# Rezoning Transportation Analysis

Petition Number: #2022-096

**From:** Jake Carpenter, PE

Date	Description
11-28-22	First Review (TM)

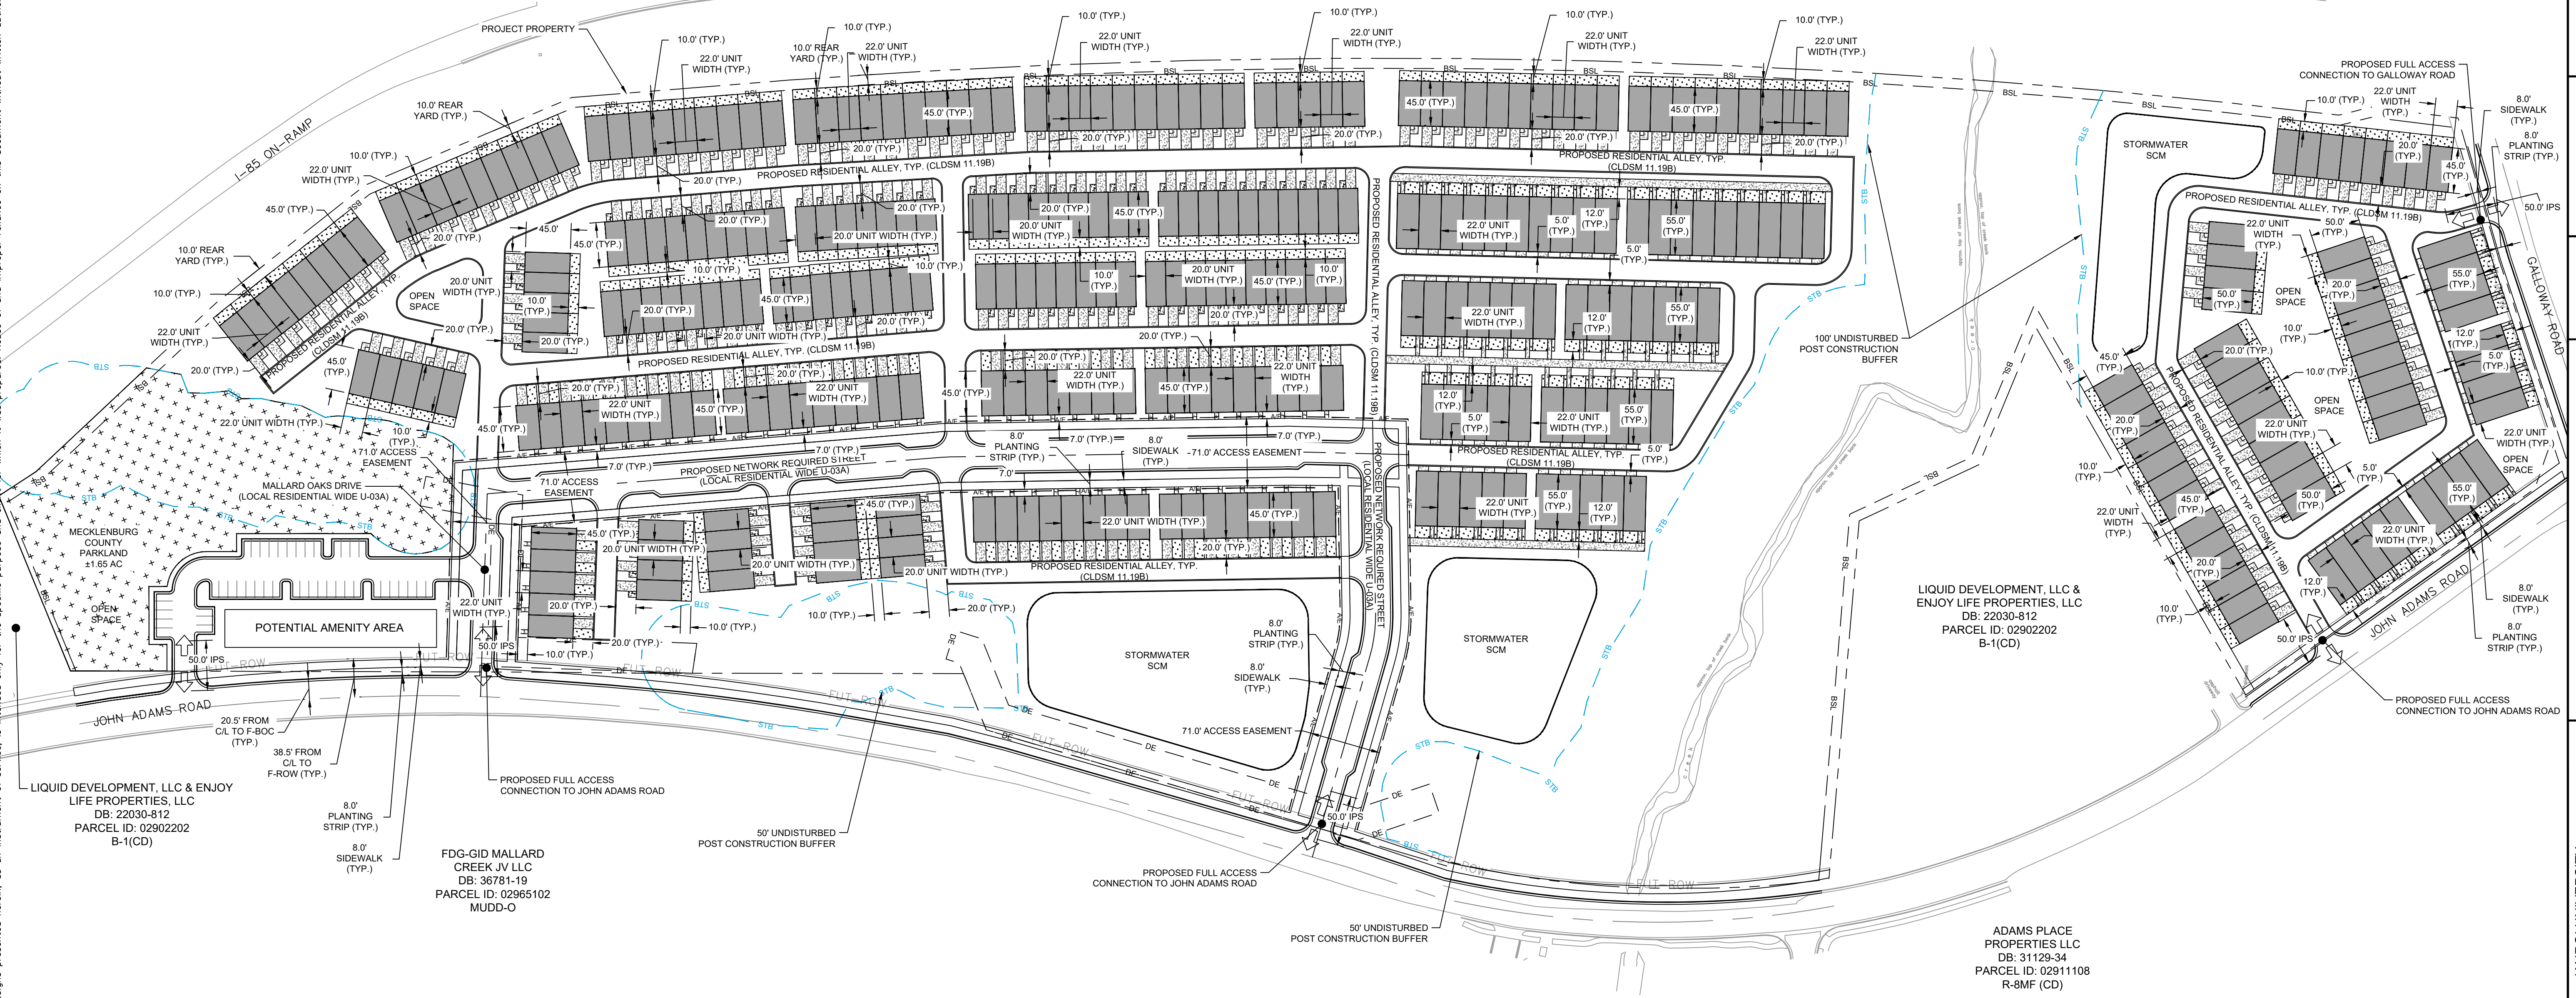
1. **Curbline:** The proposed zoning district has a setback measured from back of the existing or proposed future curbline.
  - a. **John Adams Road:** curb and gutter is located 20.5-feet from the roadway centerline to the future back of curb.

Label and dimension the curb and gutter from the centerline for each road on the site plan.

3. Revise site plan and conditional note(s) to commit to dedicate 38.5-feet of right-of-way from the road centerline. The site plan shall label and dimension the right-of-way from the road centerline.
4. Revise site plan and conditional note(s) to commit to construct an 8-foot planting strip, and 8-foot sidewalk on John Adams Road and Galloway Road per Chapter 19. The site plan shall label and dimension both items from the back of curb and gutter and road centerline.
5. The proposed dwelling units exceeds 12 per acre. Per Chapter 20 Subdivision ordinance, site plan and conditional note(s) revisions are needed to commit to construct an 8-foot planting strip, and 8-foot sidewalk along John Adams Road, Galloway Road and all internal network required public Streets. The wider sidewalk also meets the Charlotte WALKS Policy.

6. Conditional note(s) revisions are needed to commit to correcting grade break issues along John Adams Road. Add conditional note to commit to this improvement along John Adams Roadway.

7. Site plan and conditional note(s) revisions are needed to commit to dedicating right-of-way along with a slope easement along Galloway Road to allow for a future bridge over I-85 to be constructed. Site plan shall label and dimension each from the roadway centerline.
